Reference: 10 228

**Re: Mixed Commercial & Retail Development (Stage 1) - 2 Australia Avenue, Sydney Olympic Park – SOPA Response**

**Exhibition of Environmental Assessment for Mixed Commercial and Retail Development (Stage 1) at 2 Australia Avenue, Sydney Olympic Park (Site 43/44) (MP10\_0168)**

**Attach. A1.**  
 SOPA markup  
 Alternative ramp  
 locations and  
 envelope changes  
 Jan. 2012.

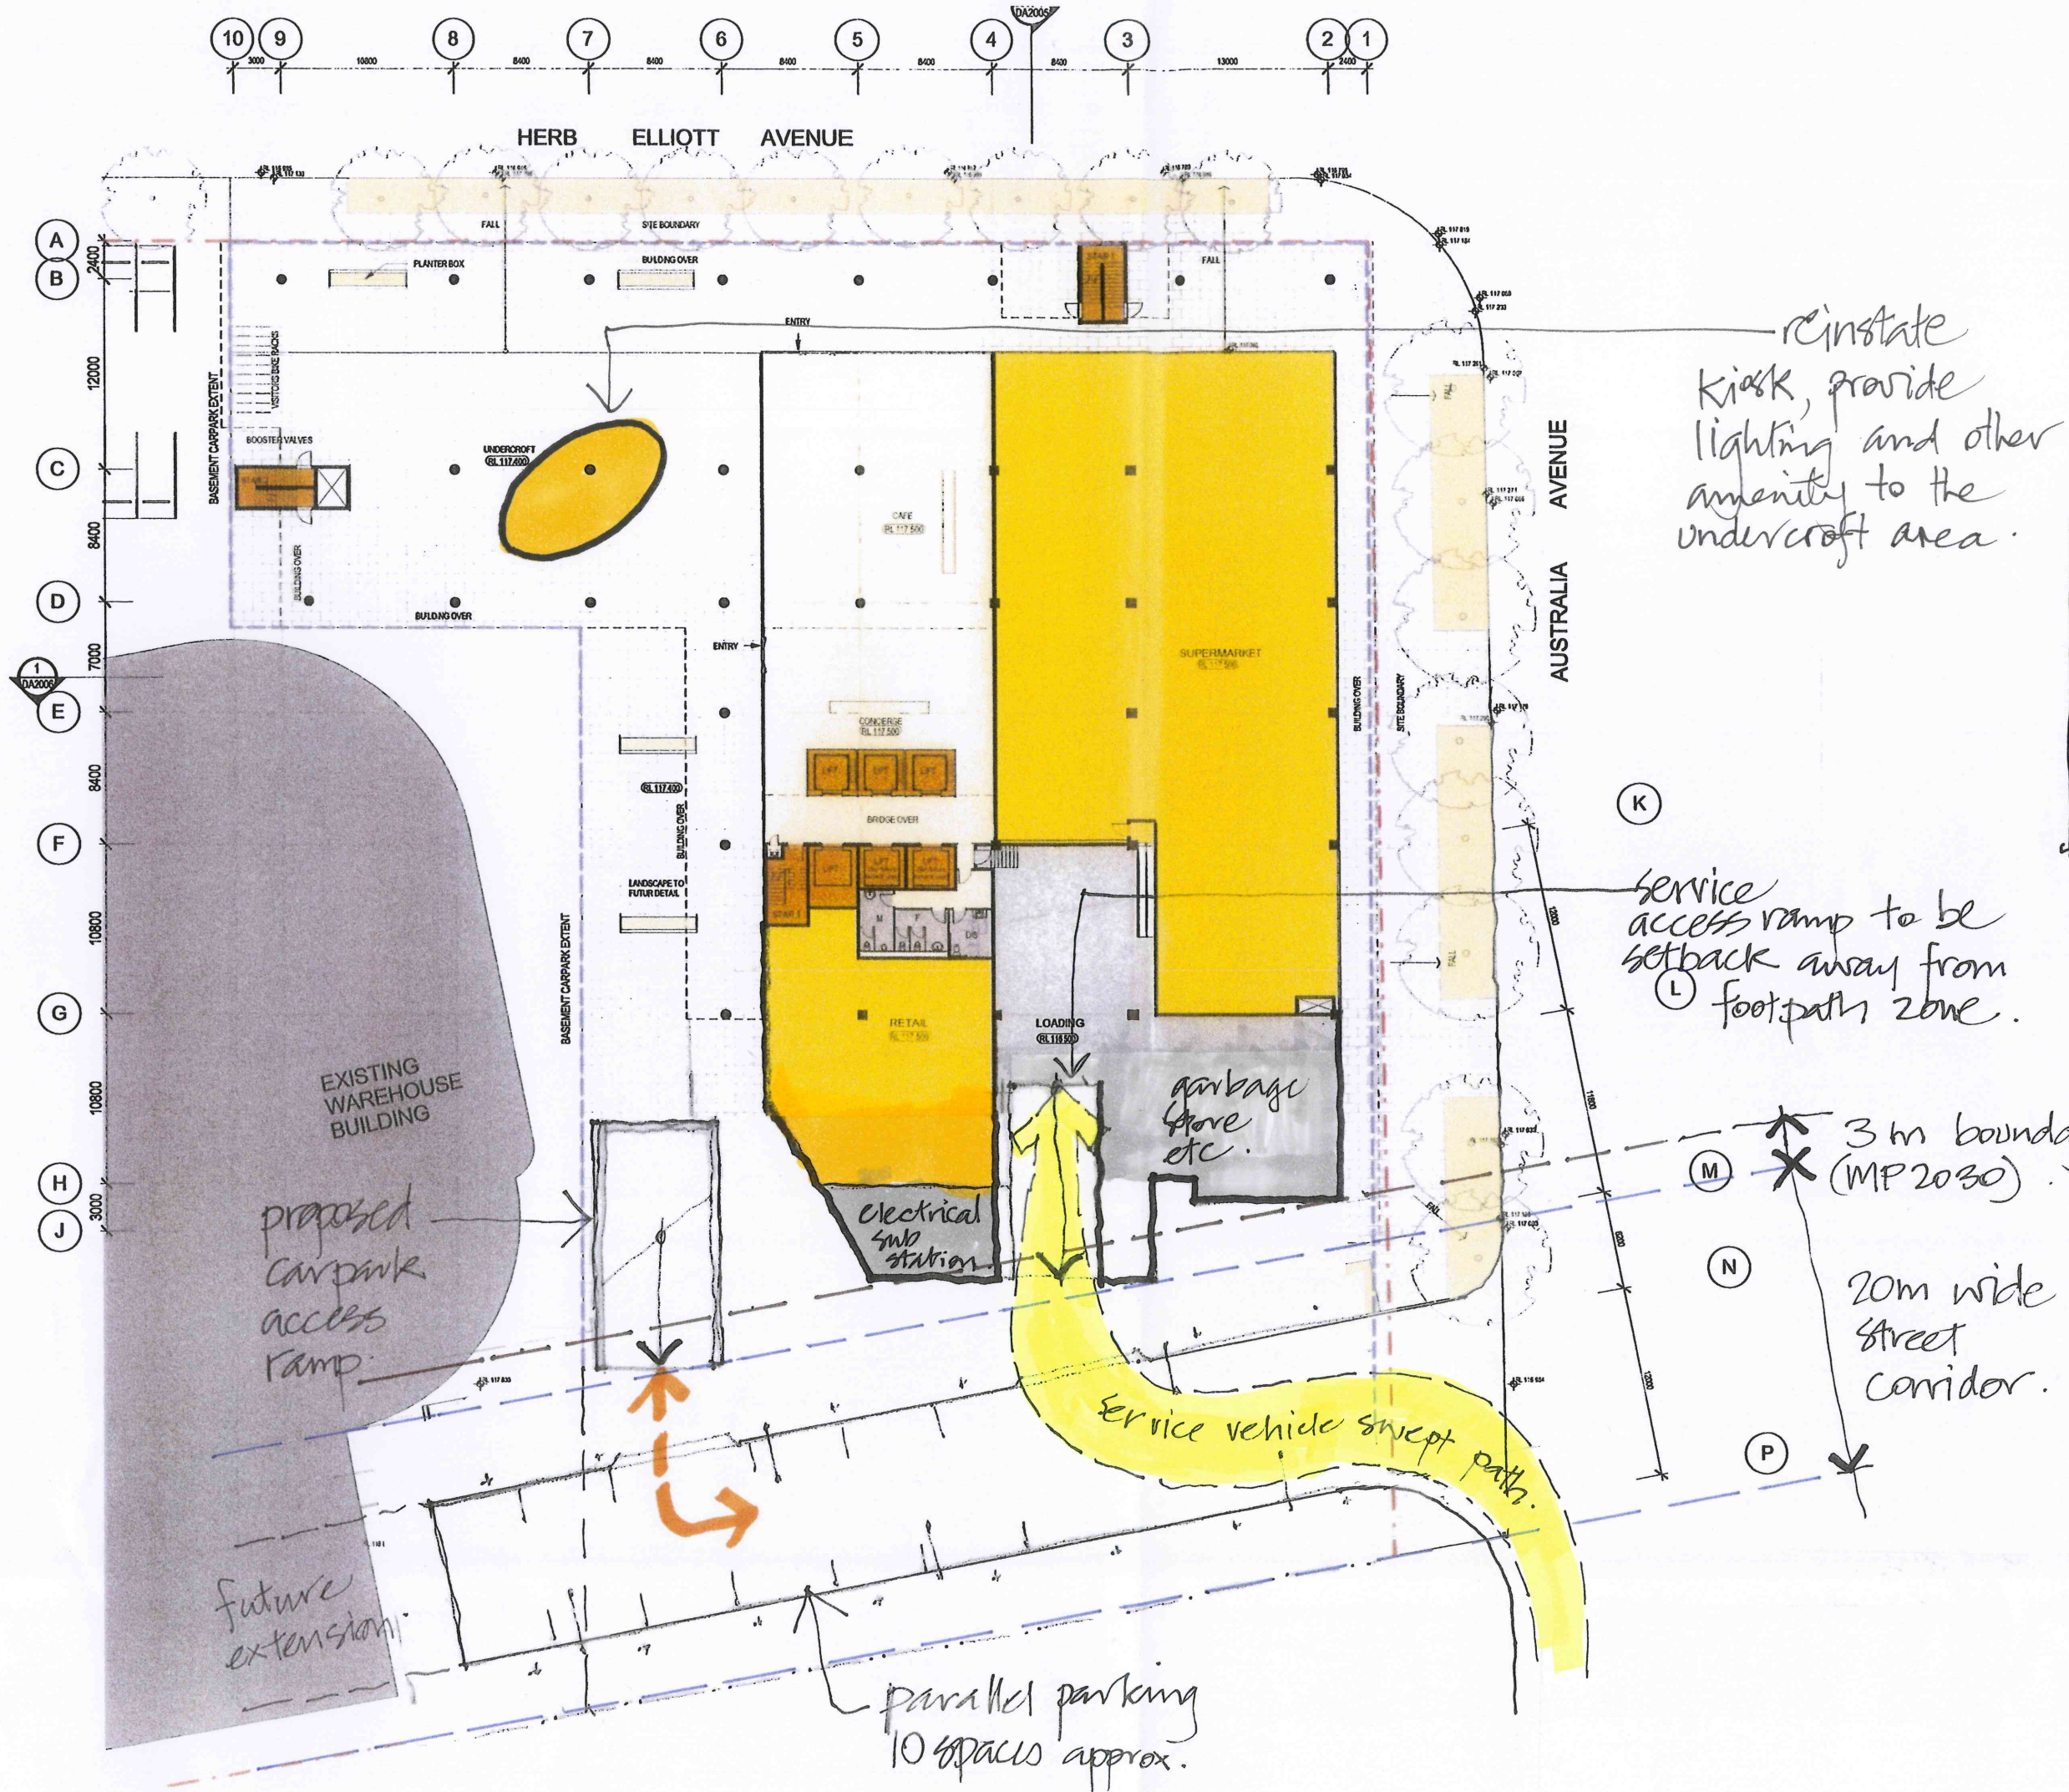
***Item (1): "The Ground Floor Plan (DA1003) shows the only access to the site for all vehicles is from Australia Avenue. This plan shows that there are three (3) access requirements for vehicles – the temporary ramp for basement parking, at grade parking for supermarket/retail customers and the site's loading area. This creates significant conflict....."***

***Item (3):" The proposed placement of the temporary ramp for basement parking has a number of shortcomings, especially in relation to the construction of New Road 10 and any vehicular access to adjacent development sites. It is recommended that the temporary ramp be relocated to an area outside of the footprint of any proposed new road...."***

**Item (5): “All vehicles entering and exiting the Loading Area must do so in a forward direction. This includes both access from Australia Ave and into the actual Loading Area of the building footprint.**

The temporary access driveway provided for Stage 1 has been re-designed and these conflicts have been resolved. The proposed new access layout is provided in **Attachment 2** and the following amendments are noteworthy:

- The Stage 1 development now proposes two separate access driveways, both of which will continue to be limited to left-in/left-out movements. This arrangement complies with AS 2890.1 although it is essential in this regard that both driveways be designed with laybacks so that they operate as a 'conventional' driveway, with pedestrians having priority. These driveways will be reconfigured to form a single public roadway for Stage 2.
- The southernmost driveway will serve the basement car park only and has a width of 6 metres which complies with the requirements of AS 2890.1 (2004) for a Category 2 driveway.
- The northernmost driveway will serve the 19 space car park and loading dock and is separated from the basement access by a 2.0 metre wide painted 'refuge' median. The

- The loading dock has been relocated further to the west. Access by an MRV (8.8 metre) can be achieved using the new access and this is demonstrated in the swept path analysis provided in **Attachment 3**.

Consultation is currently being undertaken with SOPA and Capital Corporation regarding the location of the temporary ramp. Capital Corporation has noted that a number of construction methodologies are being investigated and all maintain access to car parking at the front of the site during the entire construction period.

The loading area has been redesigned and can accommodate a turntable suitable for an 8.8metre MRV plus an additional 600mm clearance on each side. The provision of the turntable will allow all vehicles to enter/exit the site in a forward direction. Swept path analysis has been undertaken to demonstrate this and is provided in **Attachment 3**.
